Application no: H09/0691/02

Description: Removal of bay window and insertion of door,
window brickwork and canopy (retrospective)

Location: 75 High Street
Holbeach

Description: Removal of rear bay window, insertion of
door/window and provision of new steps/platform
(part retrospective)

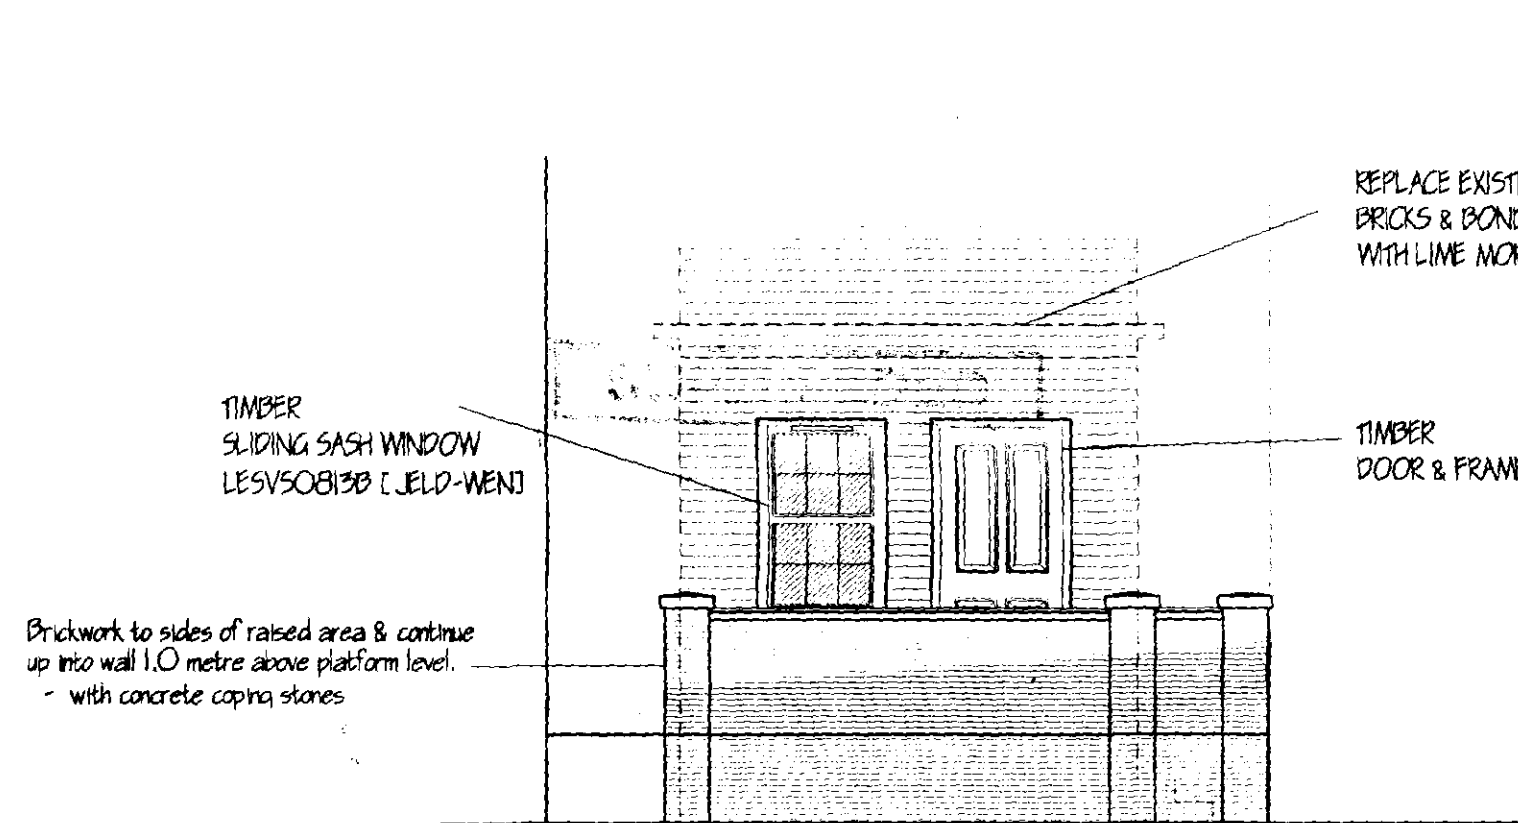
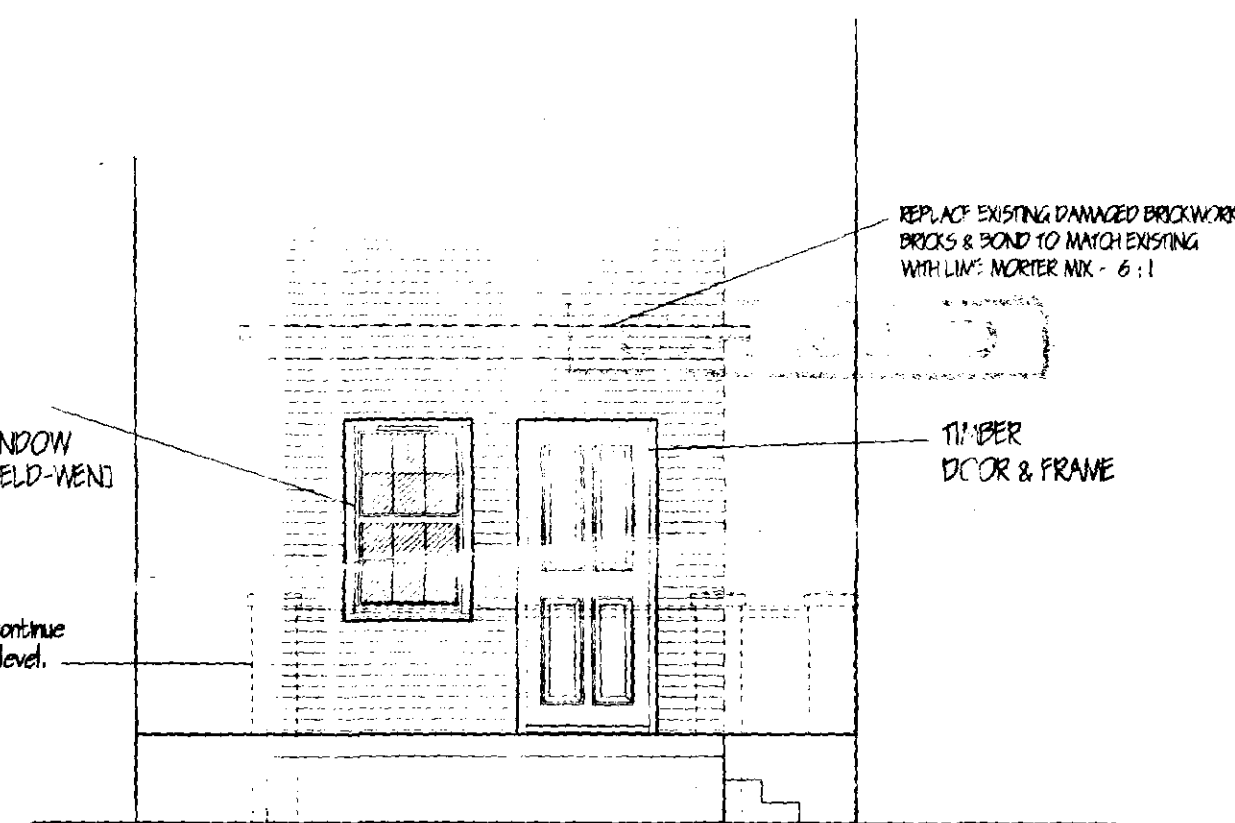
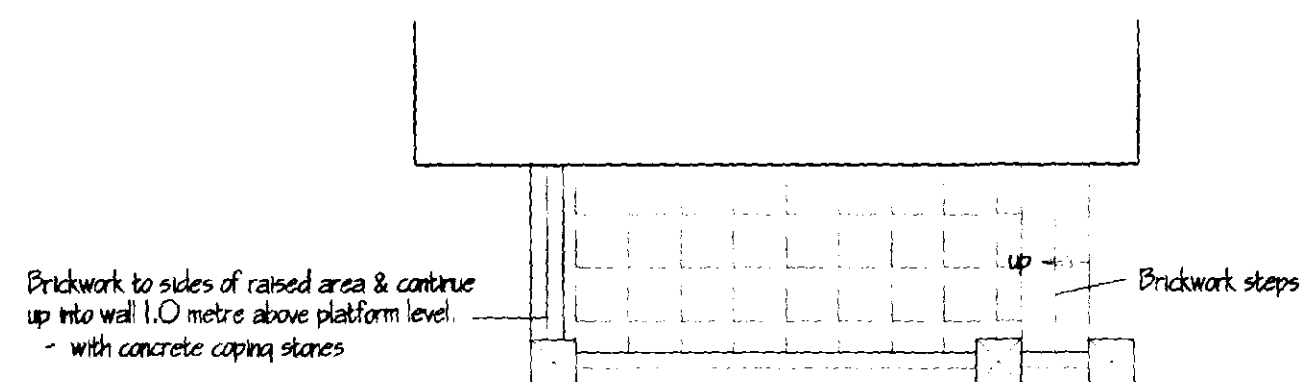
With reference to the above application and my discussions with your colleague Geoff Dewhurst please find enclosed amended plans stating your requirements for brickwork replacement: -

**REPLACE EXISTING DAMAGED BRICKWORK. BRICK & BOND TO MATCH
EXISTING WITH LIME MORTAR MIX - 6:1 RATIO.**
